CITY OF ALBUQUERQUE

**RE: Lot 15 Block 2 Unit 19 Volcano Cliffs
6508 Camino del Oeste
Grading and Drainage Plan
Engineers Stamp Date 5/15/15 (D10D003G15)**

GRADING AND DRAINAGE PLAN
LOT 15 , BLOCK 2 , UNIT 19 , VCS
ADDRESS: 6508 Camino del Oeste, NW

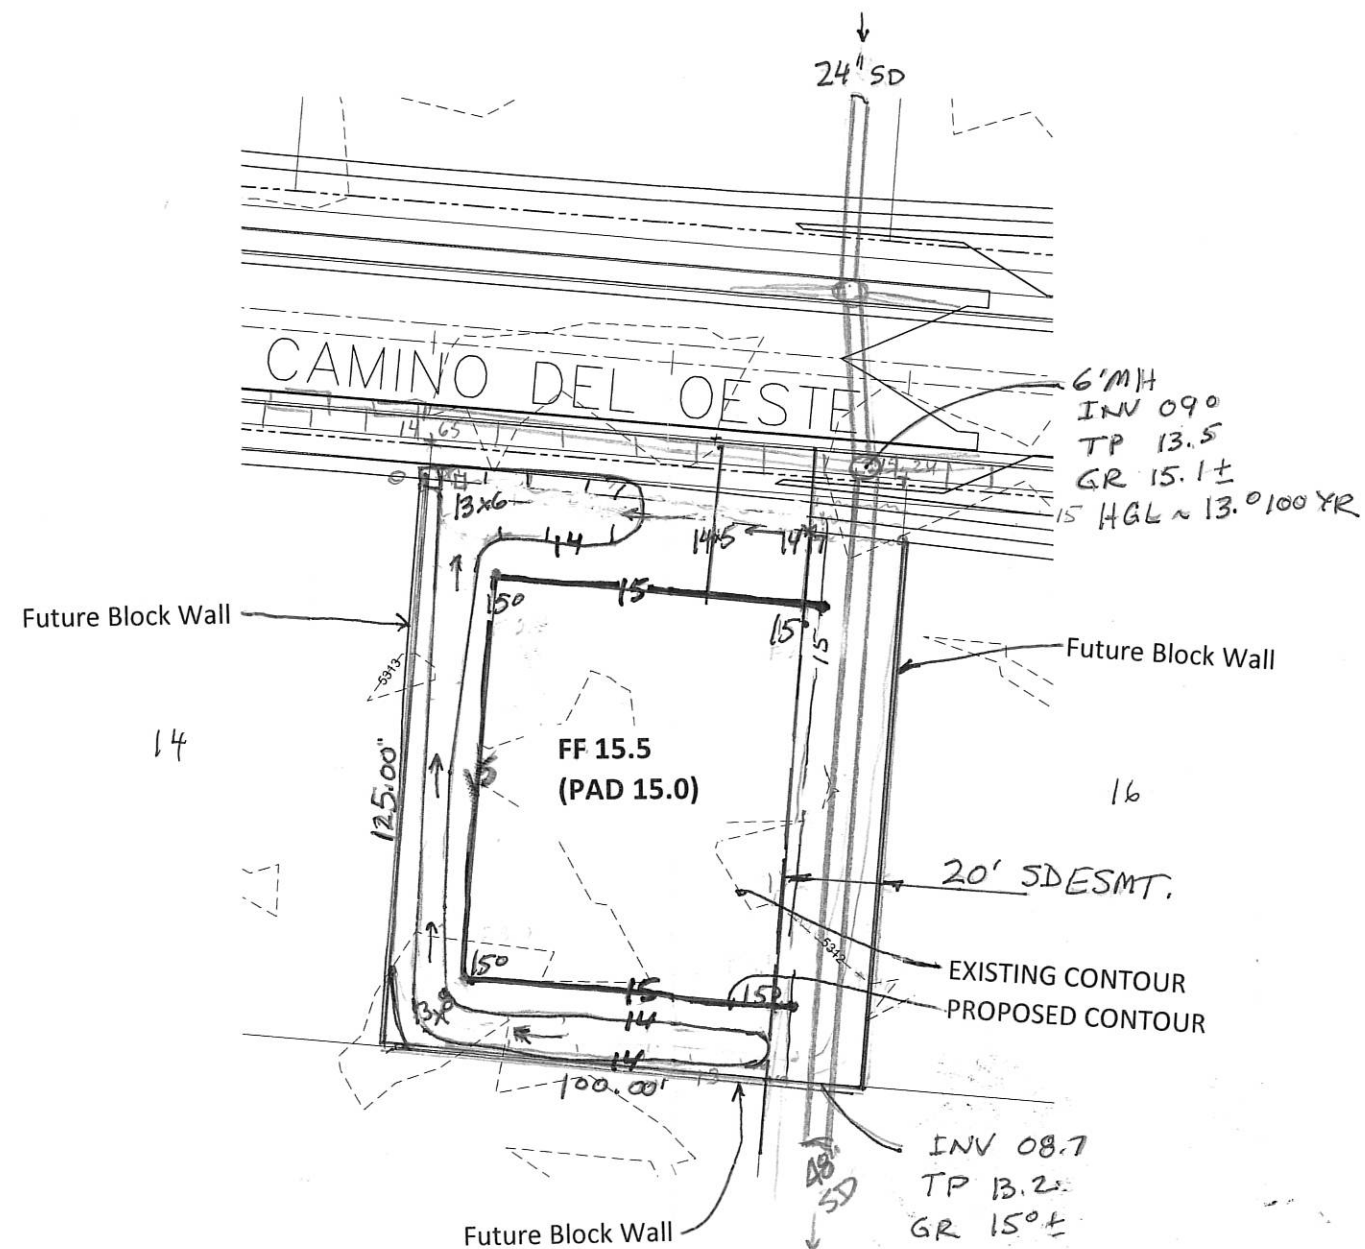
- Provide pond bottoms and WSE.
- Provide pond volumes.
